Our ref: OUT23/3591

Subject: Hunter Valley Operations North Continuation Project (SSD-11826681) and Hunter Valley Operations South Continuation Project (SSD-11826621) – Environmental Impact Statement

Detailed advice to DPE Planning & Assessment regarding the HVO North Open Cut Coal Continuation Project (SSD-11826681) and HVO South Open Cut Coal Continuation Project (SSD-11826621) – Environmental Impact Statement

HVO Continuation Project
Figure 4.2

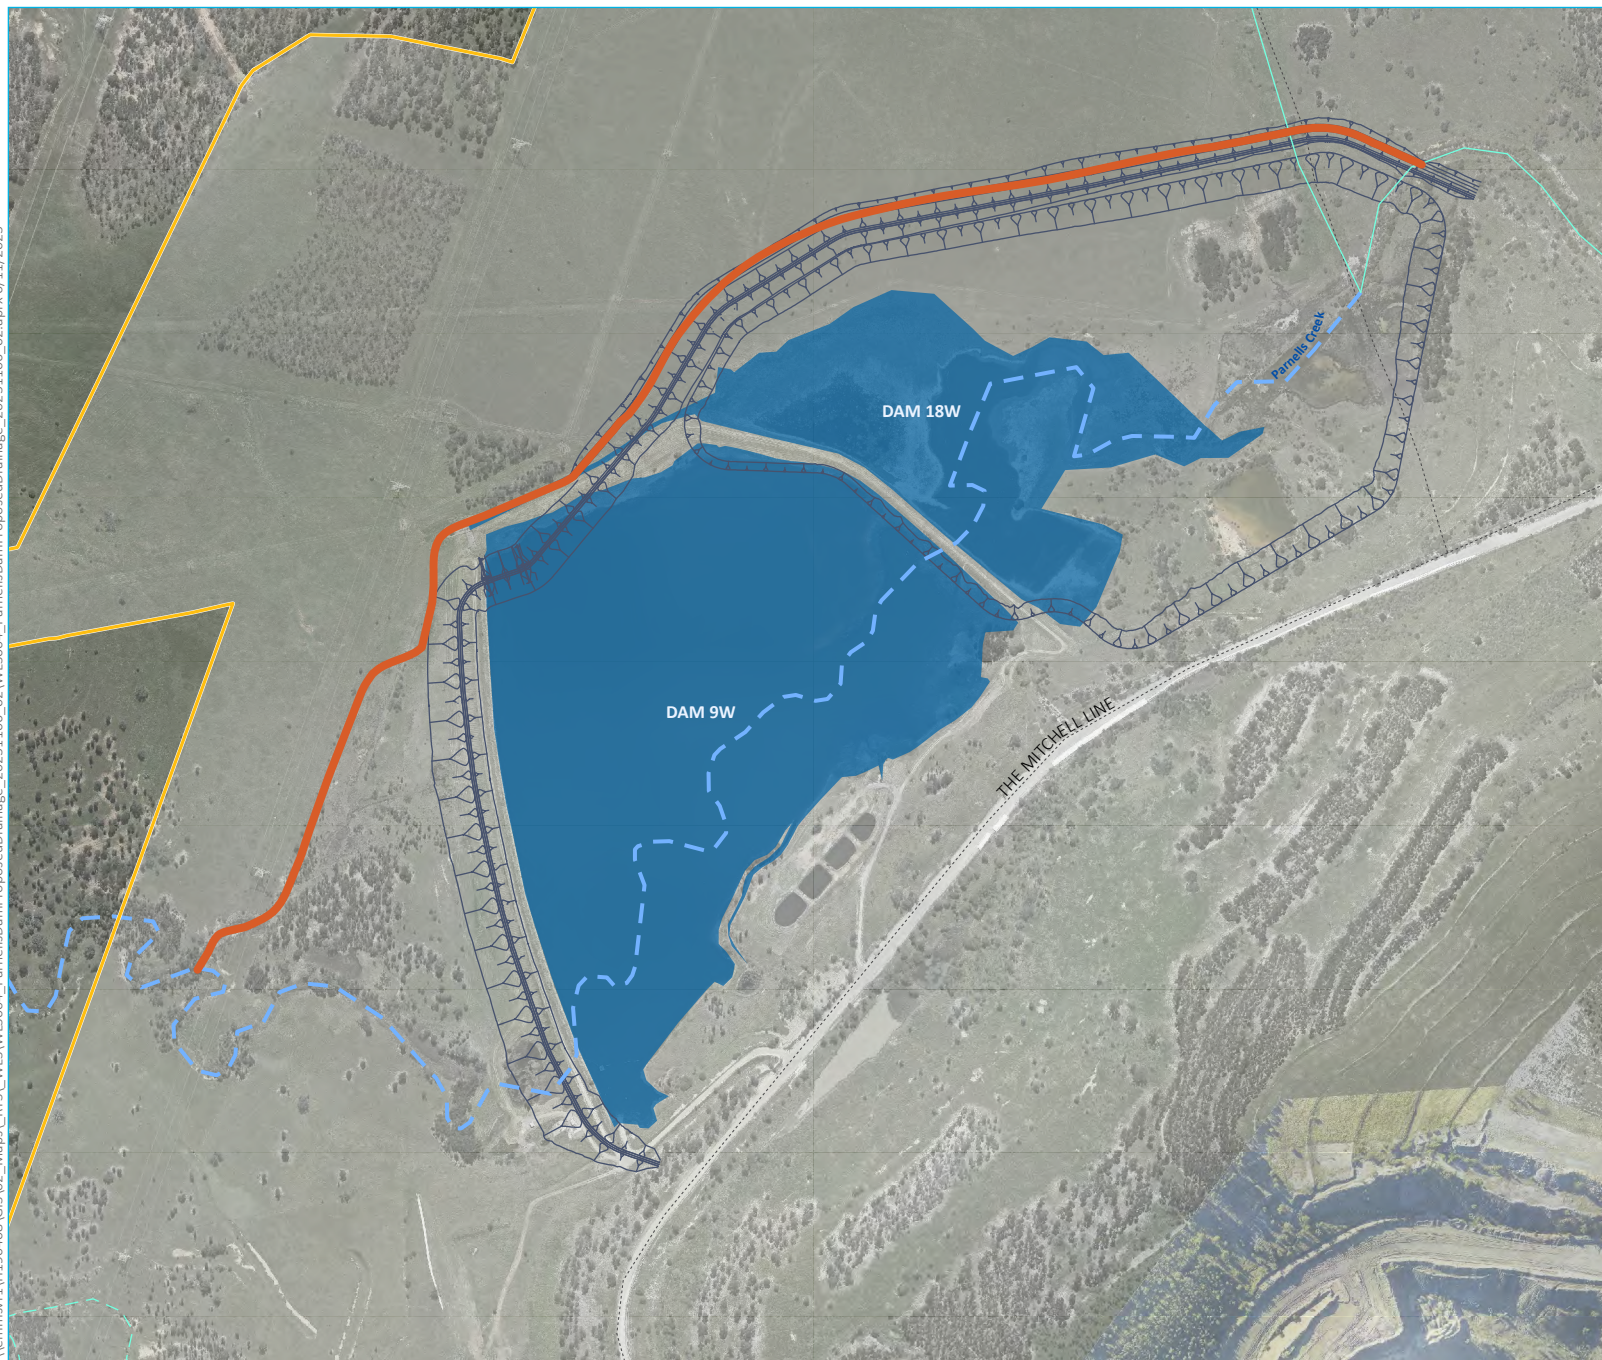
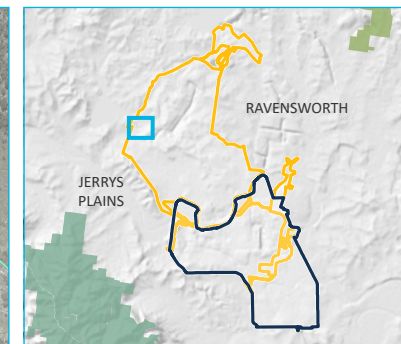
When interpreting the presence of a watercourse and its stream order for licensing purposes the hydroline layer available from the Departments website is the appropriate tool to use. This is accessible at the following link: <https://www.dpie.nsw.gov.au/water/licensing-and-trade/hydro-line-spatial-data> Please note no exemptions were deemed relevant to the water take associated with Lake James. Both Lake James and Parnell Dam are located on third order watercourses and need to be considered for licensing purposes.

Water runoff captured and used from dams constructed on third or higher order watercourses, or harvestable rights dams that exceed the MHRDC need to be quantified and accounted for by holding sufficient water entitlement.

Figure 10 - Hunter River Paleochannel

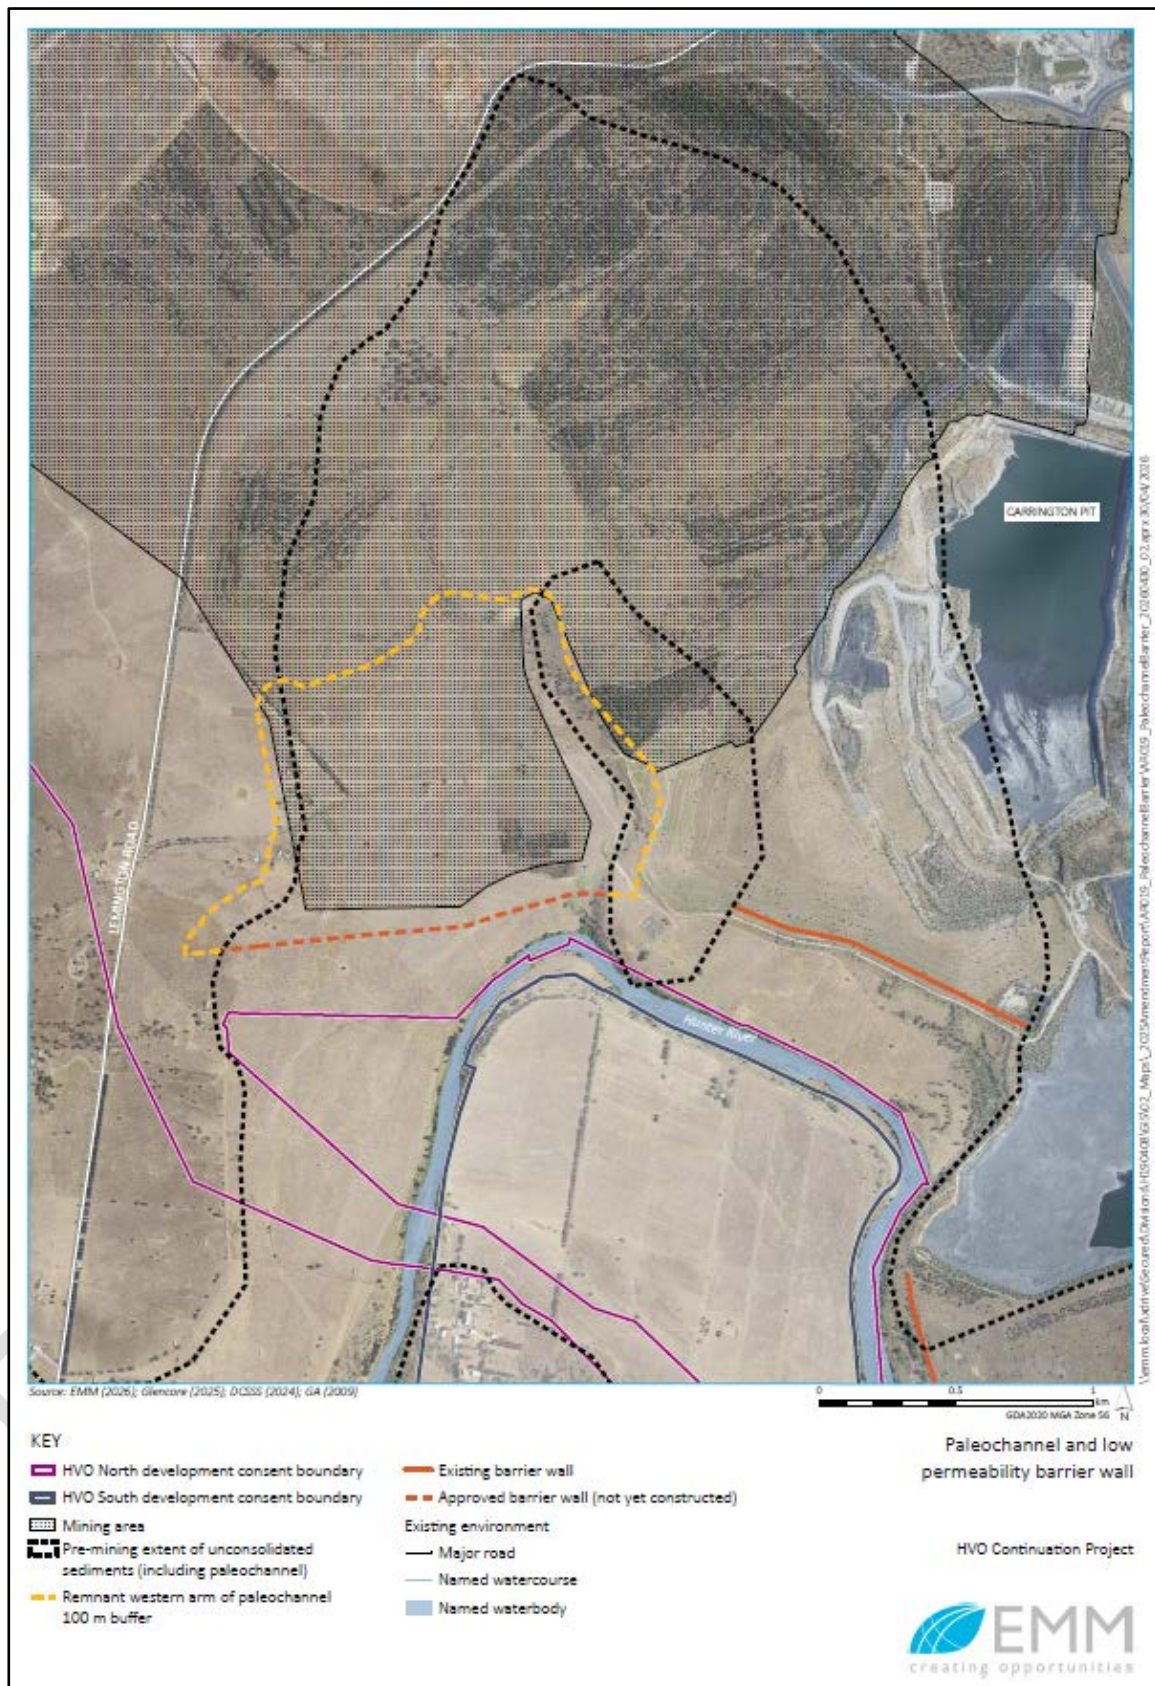
That the proposed change in location and design of the currently approved Carrington West Wing Pit low permeability barrier not be supported due to potential increased risk to the Hunter River, the alluvium and water users. It is recommended one of the following two options be implemented to mitigate this risk:

1. Implement a 150m setback between the West Carrington Pit and the edge of the Hunter Regulated River Alluvial Water Source. This would be consistent with the guideline, “*Management of stream/aquifer systems in coal mining development – Hunter Region (DIPNR 2005)*” and remove the requirement for the installation of a low permeability barrier.
2. If a low permeability barrier is to be maintained, that its construction occur prior to mining as currently approved, and that this include a demonstration of its performance consistent with current consent requirements in conditions 23 and 24 of development consent DA 450-10-2003.

The current proposal is to construct the low permeability wall on the benches of the highwall that intercept the alluvium after mining. This differs from the approved barrier wall design which requires excavation of a trench prior to mining across the inferred extent of the paleochannel alluvium and keyed into unweathered rock.

The existing approval for mining at Carrington West Wing requires the barrier wall to be constructed prior to mining, and that mining should cease within 100 metres of the paleochannel should the barrier be identified to not be achieving its performance objectives and measures. This requirement is a key mitigating measure during and post mining to reduce the extent of drawdown and protect the alluvial aquifer, Hunter River and their dependent ecosystem and other water users. This approach is consistent with the avoid/prevent strategy to mitigate impacts and should be implemented where possible. DPE Water considers a significant risk exists of a hydrological connection between the Hunter River/alluvial aquifer and the mine pit that requires a precautionary approach.

The proposal to construct the barrier wall after mining is of significant concern to DPE Water. This is because it will not provide the opportunity to establish a mechanism to
